**Our ref:** HA/2021/123332/01-L01  
**Your ref:** FP/90/21/PD  
**Date:** 12 July 2021

**NOTIFICATION OF PRIOR APPROVAL UNDER SCHEDULE 2, PART 3, CLASS M OF THE TOWN & COUNTRY (GENERAL PERMITTED DEVELOPMENT (ENGLAND) ORDER (AS AMENDED) FOR THE CHANGE OF USE FROM SHOP (A1) TO RESIDENTIAL (C3). 23A FELPHAM ROAD FELPHAM PO22 7DA**

**Environment Agency Position**

Drg. no. 2017/02 Sept. 2020
O'NEILL ARCHITECTURAL SERVICES
Tel: [01243] 531333

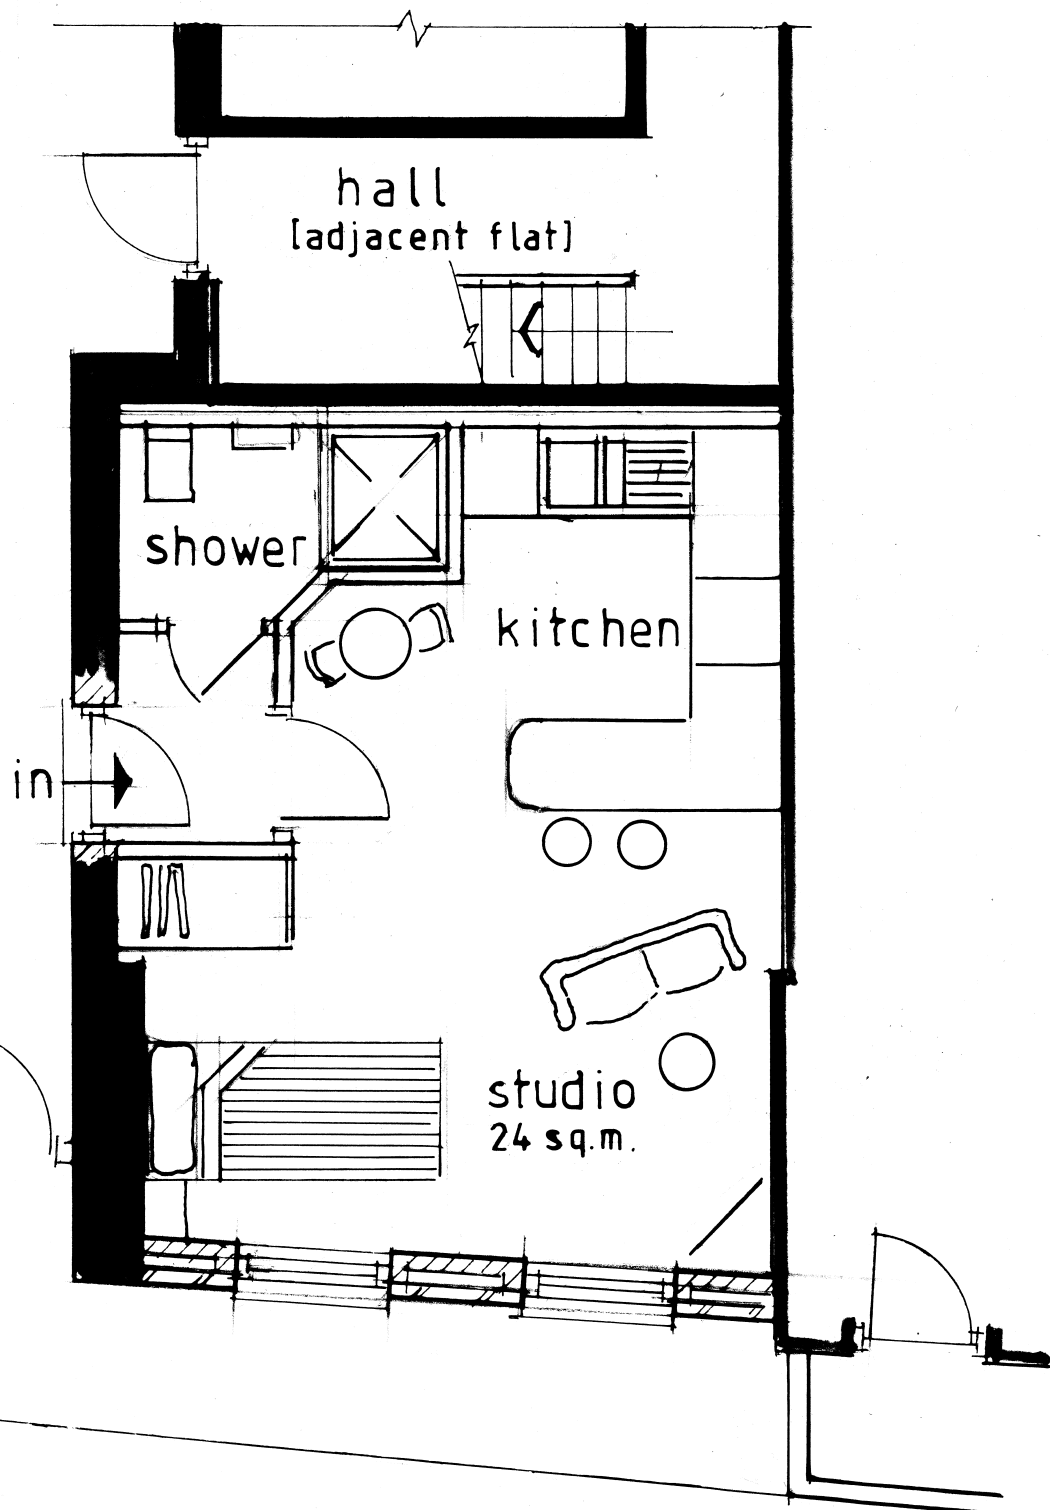
- consider how people will be kept safe from the identified flood hazards
- consider how a range of flooding events (including extreme undefended events) will affect people and property
- consider how flood defences can fail or be overtopped, therefore undefended scenarios need to be used
- consider the requirement for flood emergency planning including flood warning and evacuation of people for a range of flooding events up to and including the extreme event
- consider how placing sleeping accommodation on the ground floor, with no safe refuge on upper floors, places occupants at a danger of flood risk

To overcome our objection, the applicant should submit a revised FRA which addresses the points highlighted above.
